March 23, 2018

**RE: Heritage Trails Subdivision
Drainage Report and Grading Plan
Engineers Stamp Date: 3/15/18
Hydrology File: N08D006F**

Based on the information provided in your submittal received on 3/15/18, the Drainage Report and Grading Plan cannot be approved for Preliminary Plat or Grading Permit until the following are corrected and a revised Drainage Report and Grading Plan are submitted.

SECTION F - POND DETAIL

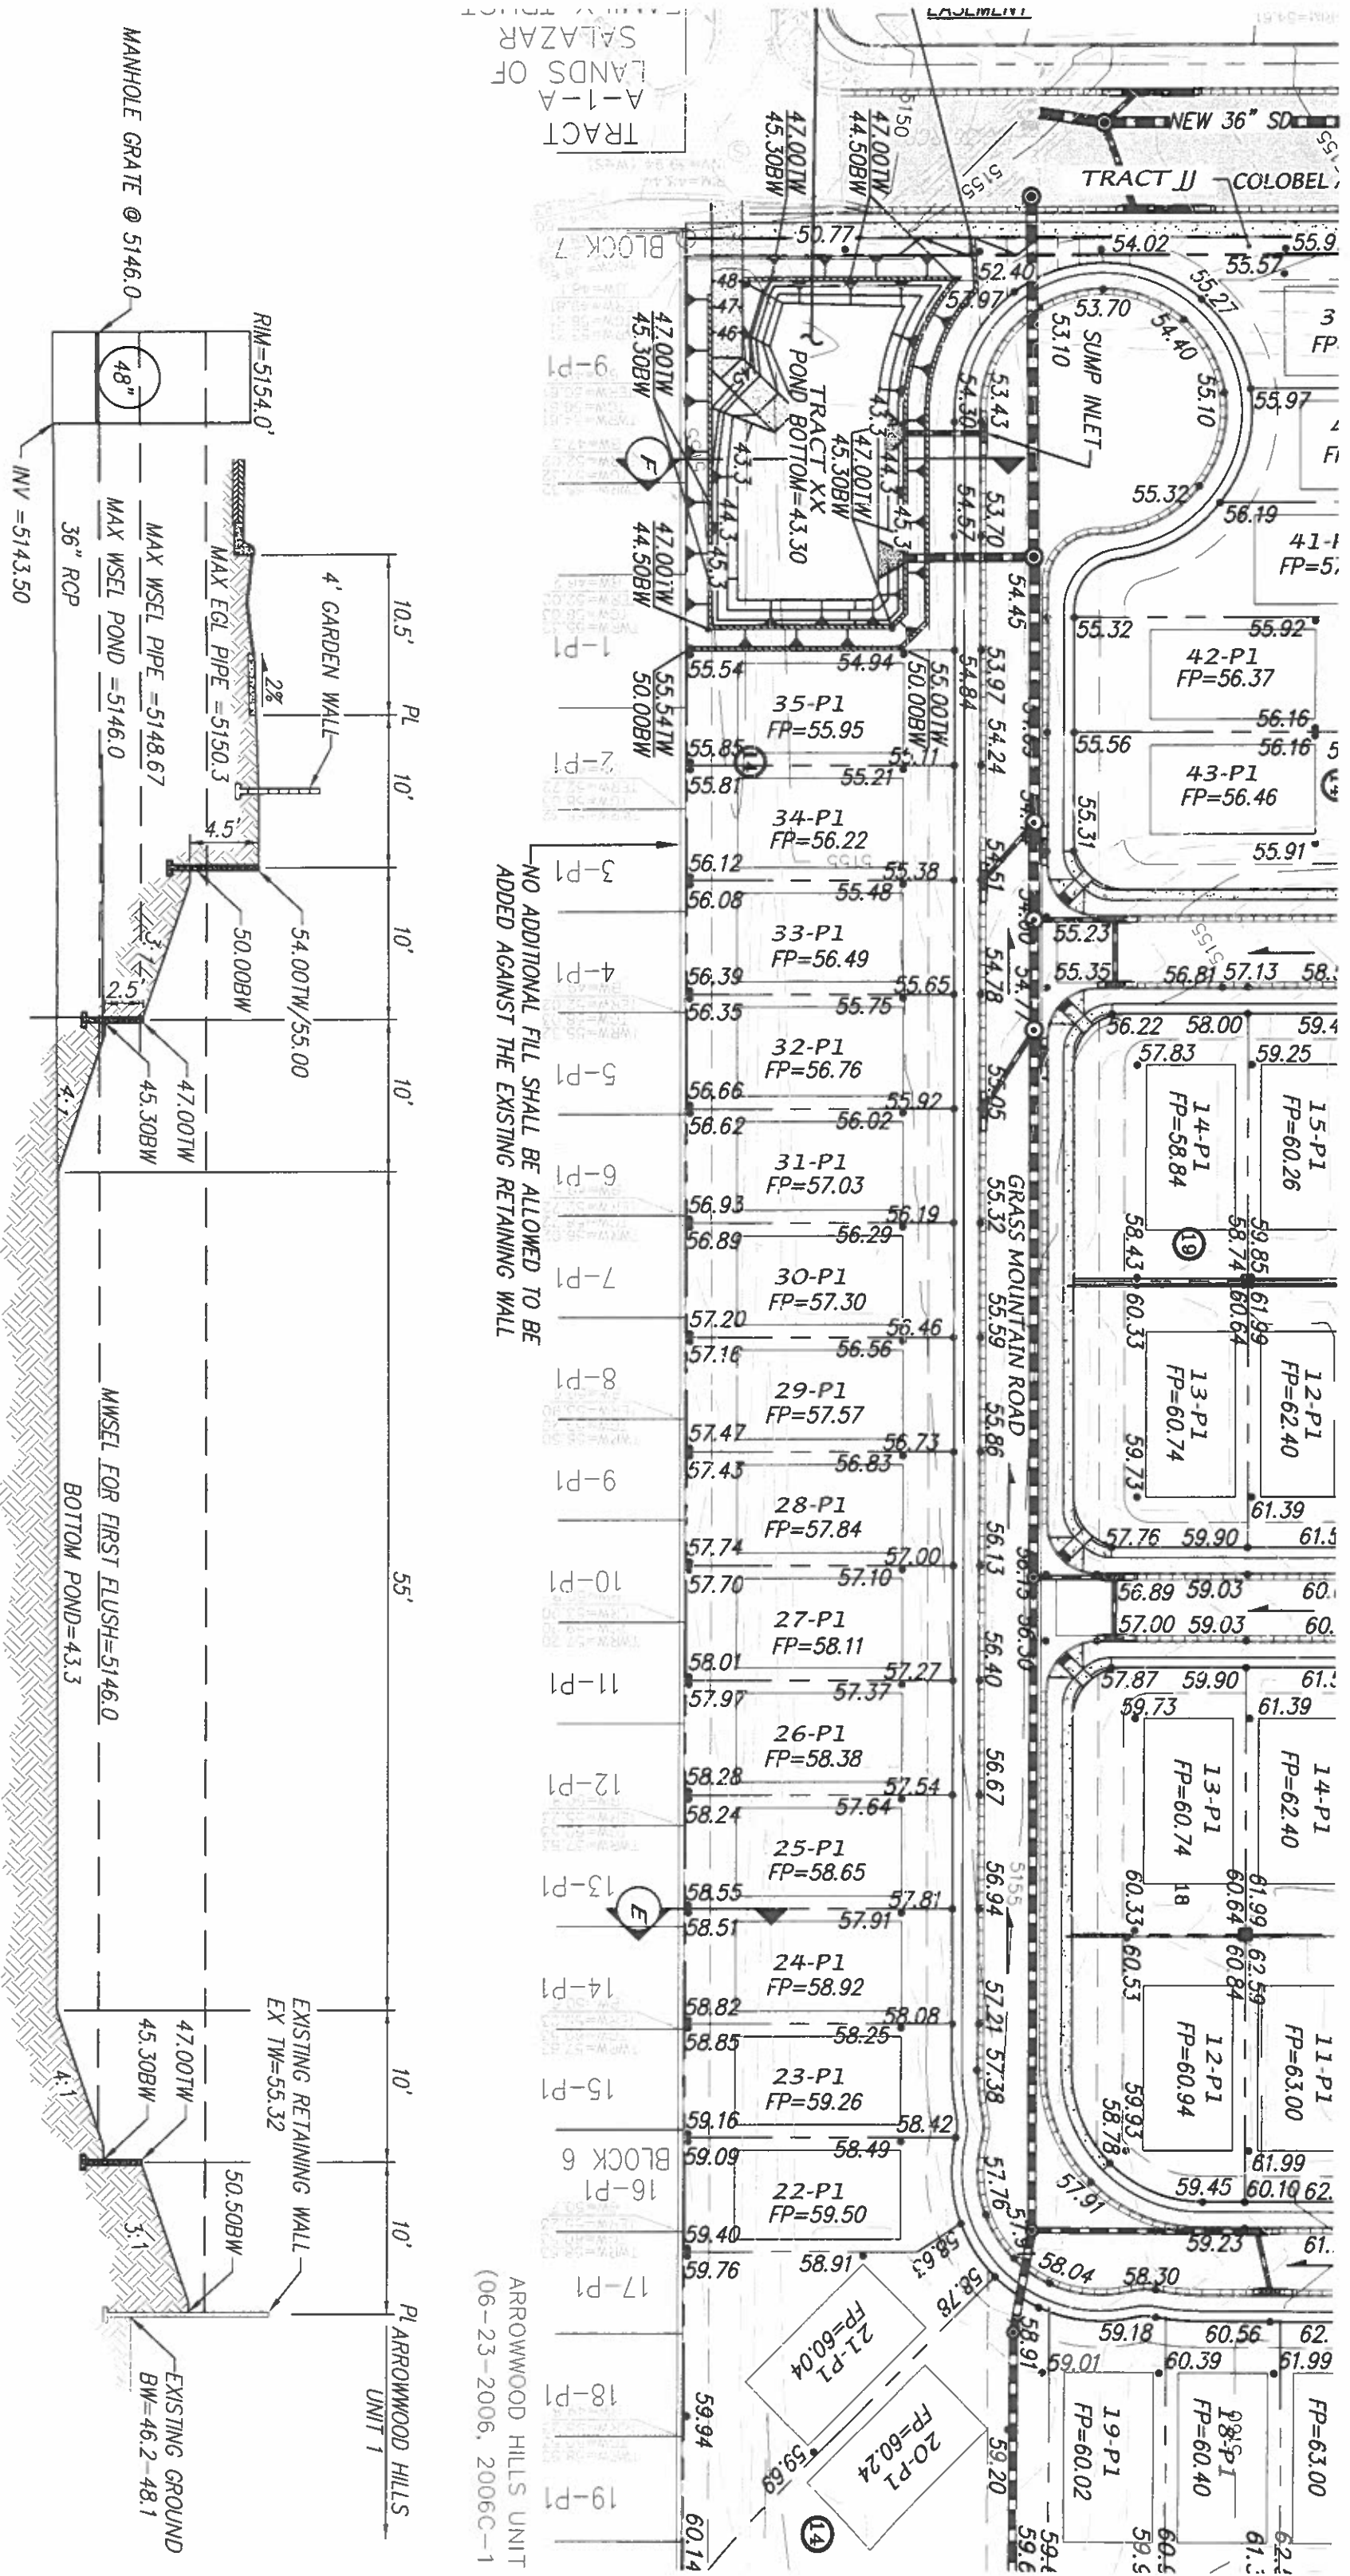
- a. Tract XX (first flush pond, required volume=20,683CF)
6. The following tracts in Units 2 and 3 will need to be dedicated as private drainage easements maintained by the owners of the subdivision by using the easement language for "*Drainage Facilities and/or Detention Areas Maintained by Lot Owner*" defined in the DPM, Chapter 21, Section 4, Part A.:

TITLE: **HERITAGE TRAILS SUBDIVISION**
OVERALL GRADING & DRAINAGE PLAN

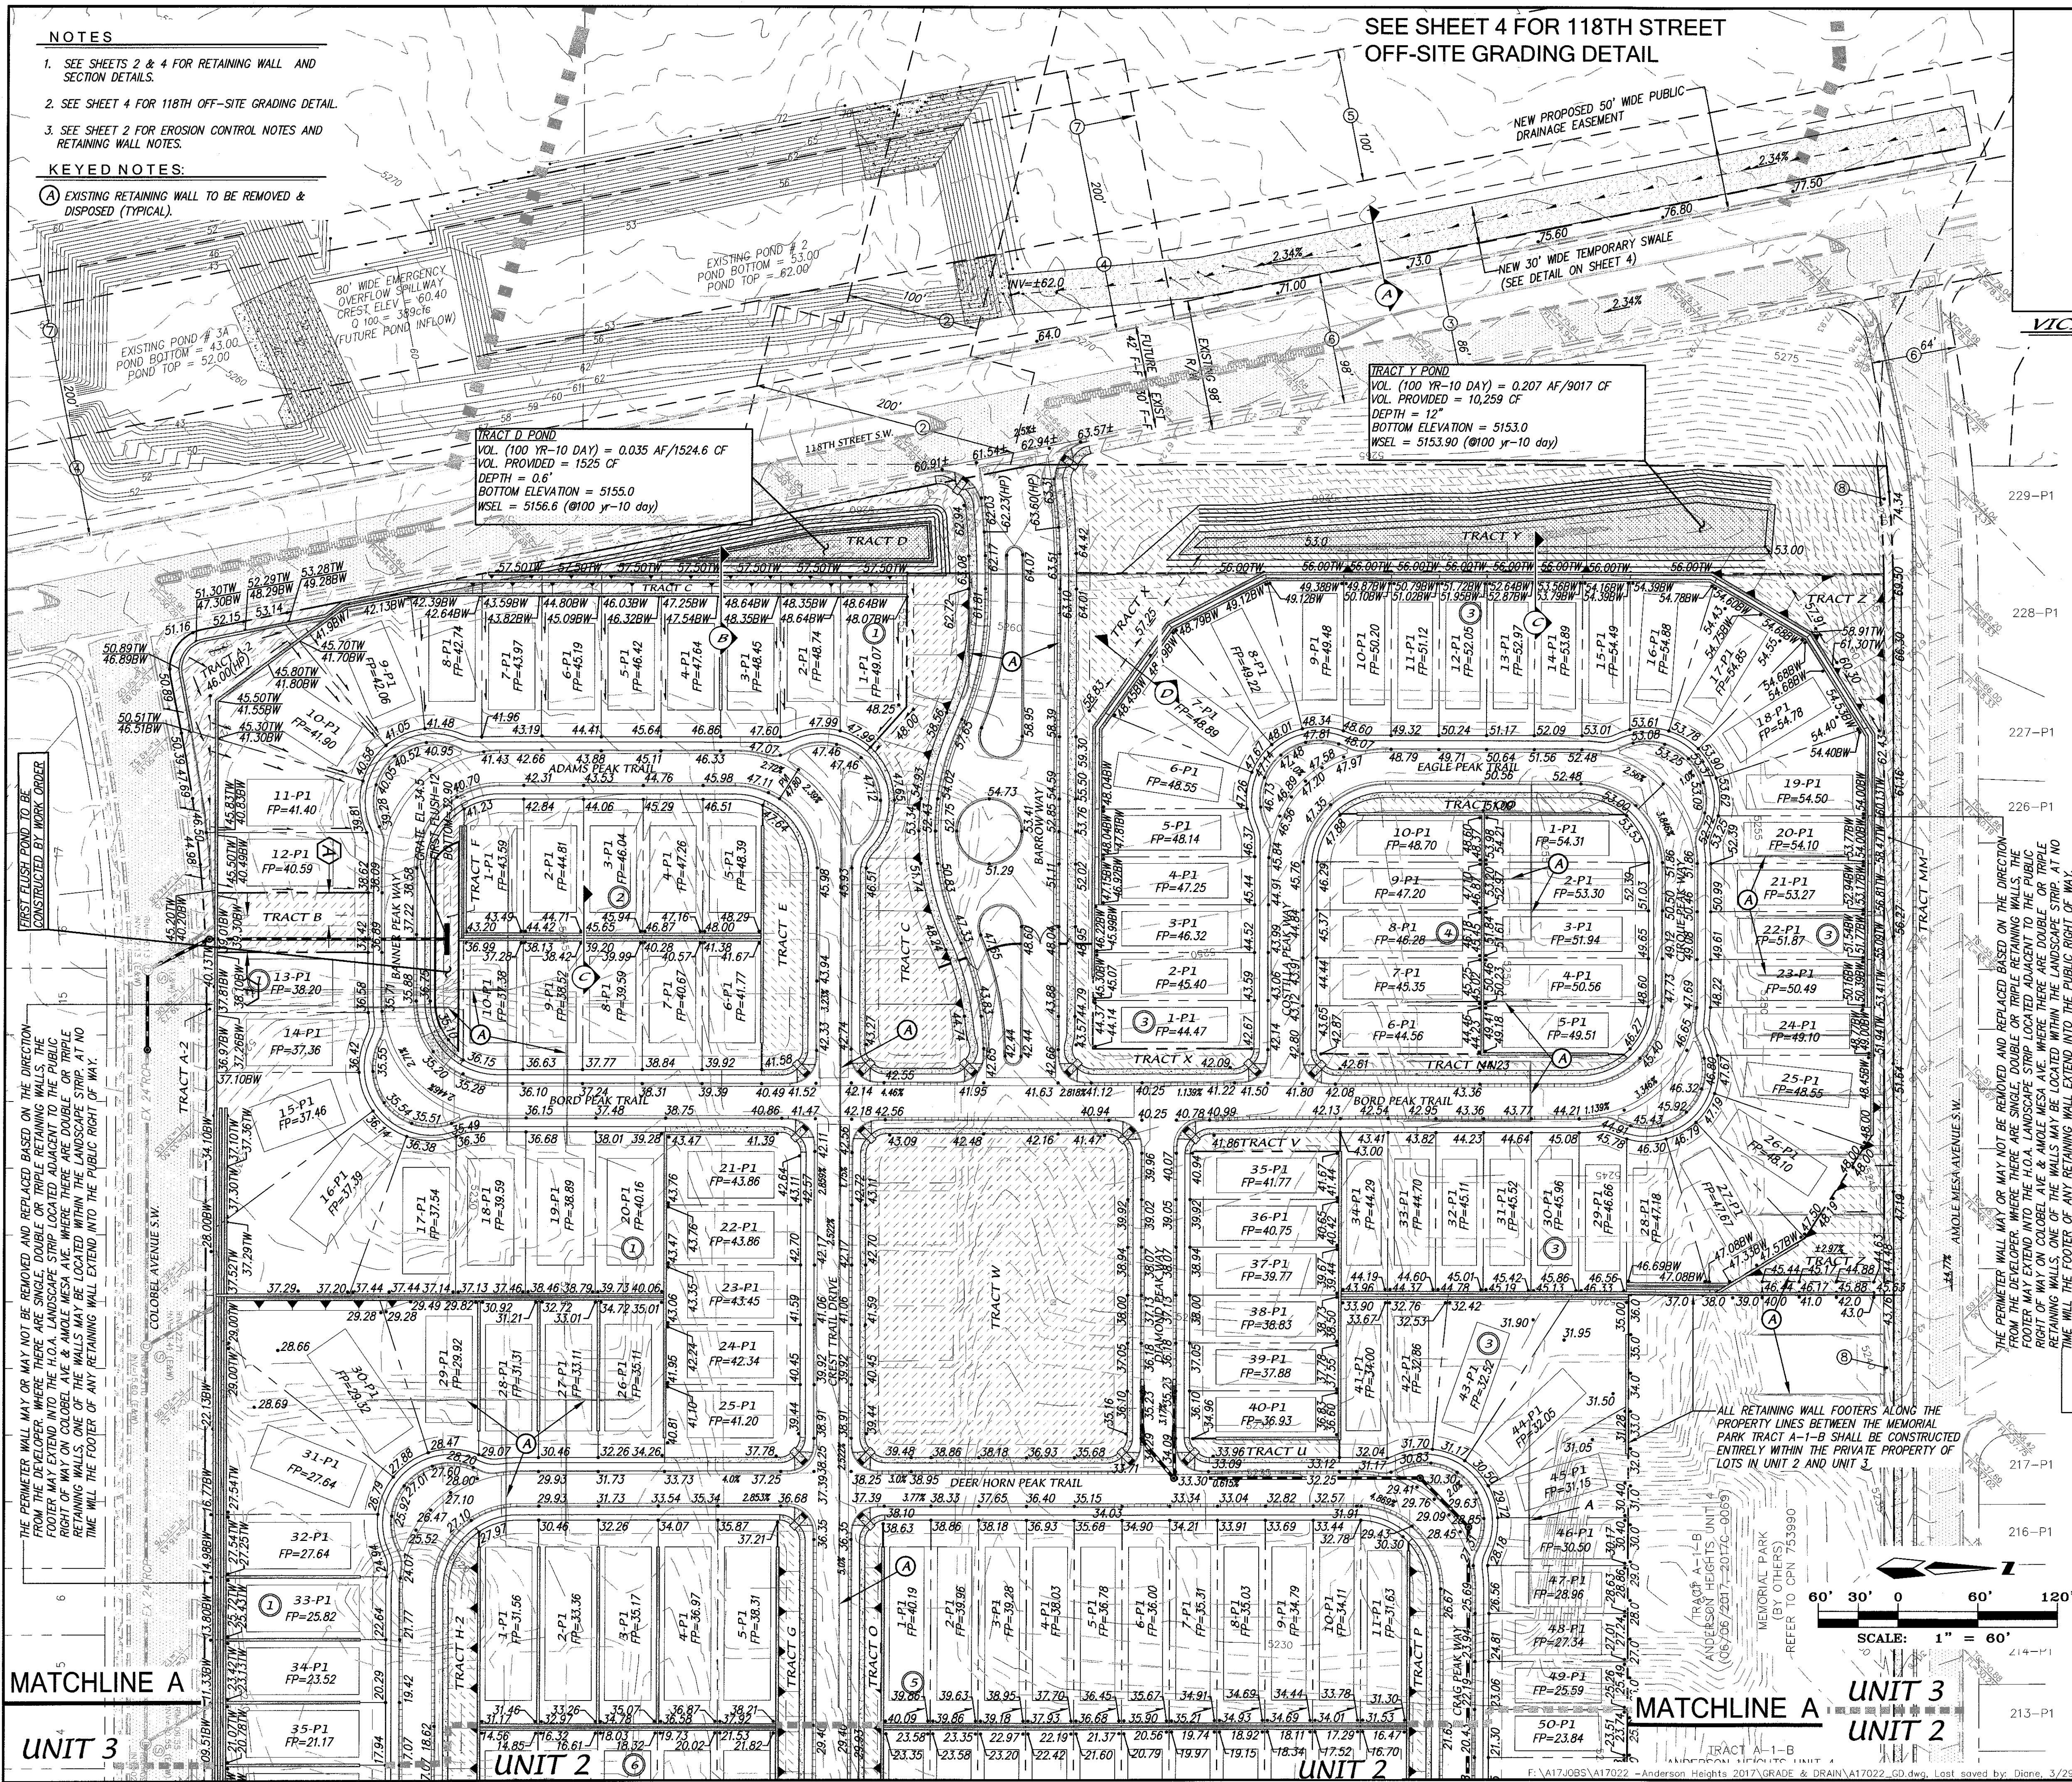
8. Correct the pad elevation on Unit 3, Block 4, Lot 10.
9. Please add the dimensional data to the Tract Y pond, similar to the Tract D pond.
10. The waterblock on Tyler Peak Trail, north of Crest Trail Drive does not make sense with respect to the spot elevations provided, please correct.

12. Between Unit 1, Block 3, Lot 28 and the memorial park. Provide a cross section here showing the retaining walls and their footers as contained on Lot 28.

13. Clarify Section E-E (the wall section along the boundary with Arrowhead Subdivision) to show that no new fill is being placed against the existing wall. Show and label the existing vs. proposed grades (typ.) and add a note that "no additional fill is to be placed against the existing wall".

14. Provide typical wall sections along Colobel and Amole Mesa showing property lines and horizontal and vertical dimensions. Show the existing perimeter wall to remain or to be removed; assuming it's just a garden wall, it may be appropriate to condition is removal on the grade change from one side to the other (<2' grade change for garden wall).

15. Add the typical swale detail as discussed (10:1.5 v-ditch, I believe) and callout where used.
16. Please provide the Curb and Gutter Exhibit (referenced on the infrastructure list footnotes).

AMENDED PRELIMINARY PLAT HERITAGE TRAILS WITHIN THE TOWN OF ATRISCO GRANT PROJECTED SECTIONS 5 AND 8 TOWNSHIP 9 NORTH, RANGE 2 EAST, NMMP CITY OF ALBUQUERQUE BERNALILLO COUNTY, NEW MEXICO MARCH, 2018

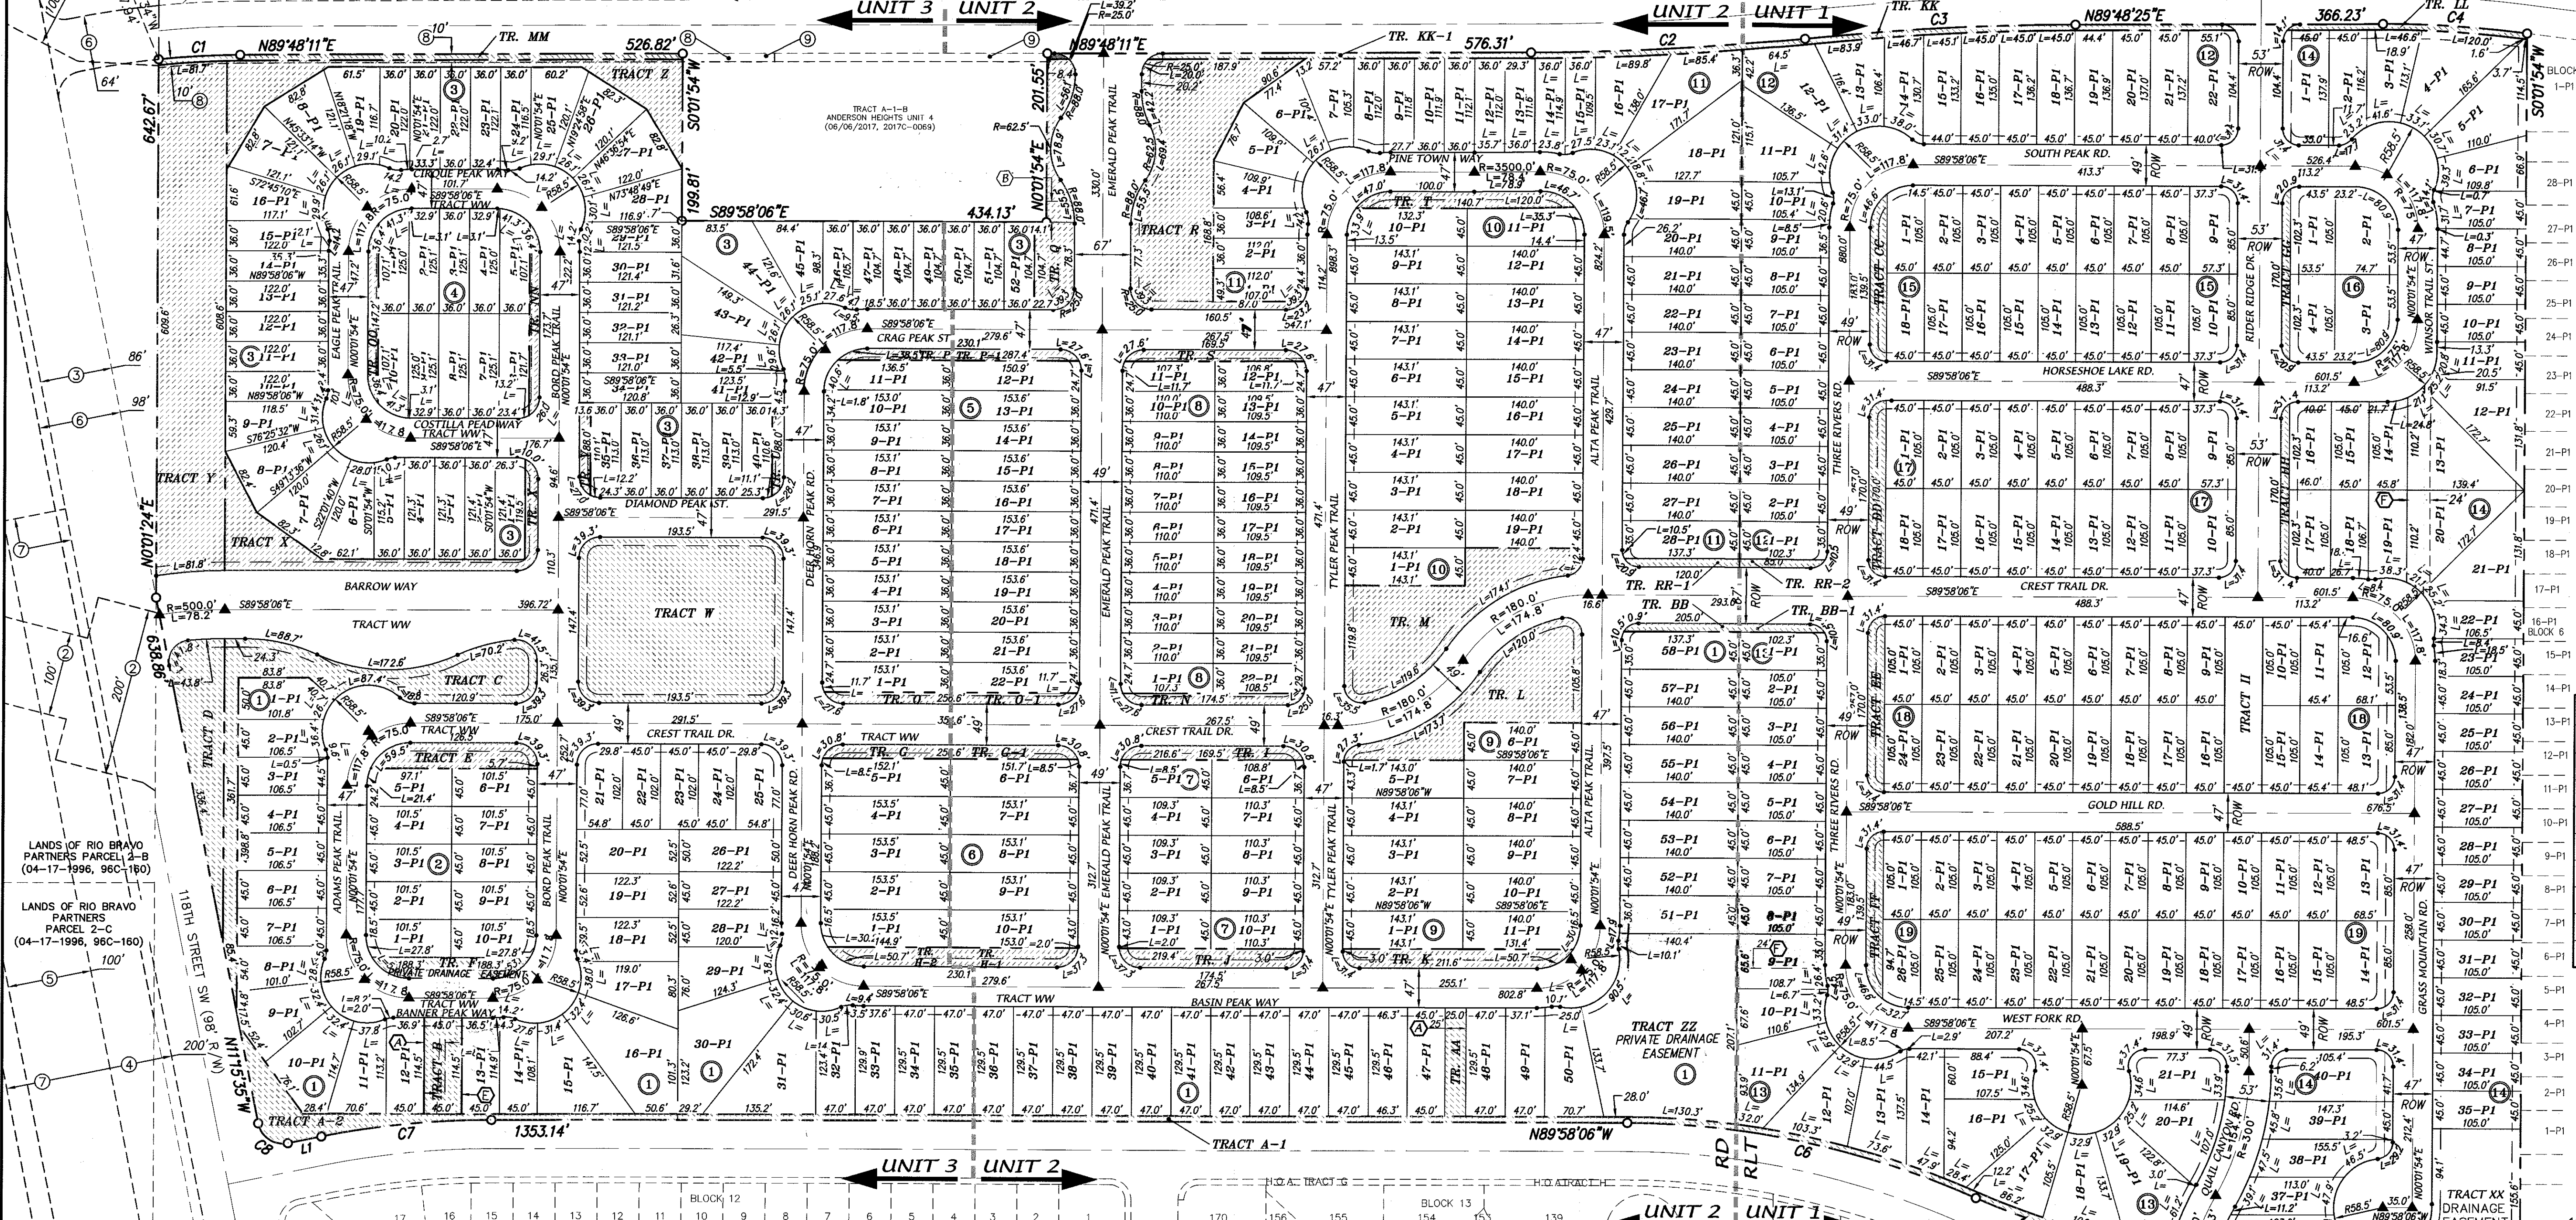
- i. Tract Z (swale)
 - j. Tract ZZ (first flush pond, volume required=28,857CF)
7. Cross-lot drainage easements are needed on the following lots/tracts:

- a. Unit 3, Block 1, Lots 9, 10, and 11 for the benefit of Tract A-2, to be maintained by the owners of Lots 9, 10, and 11, unless these lots are extended to include the corner of Tract A-2 at Colobel and 118th.

- b. Unit 3, Block 1, Lots 1-9 for the benefit of Tract C, to be maintained by the owners of Lots 1-9, unless these lots are extended to contain the terraced portion of Tract C.

- c. The drainage easement on Tract Q (near the memorial park) needs to a cross lot drainage easement for the benefit of Tract A1A to be maintained by the owner of Tract Q; not a stormdrain easement as currently shown.
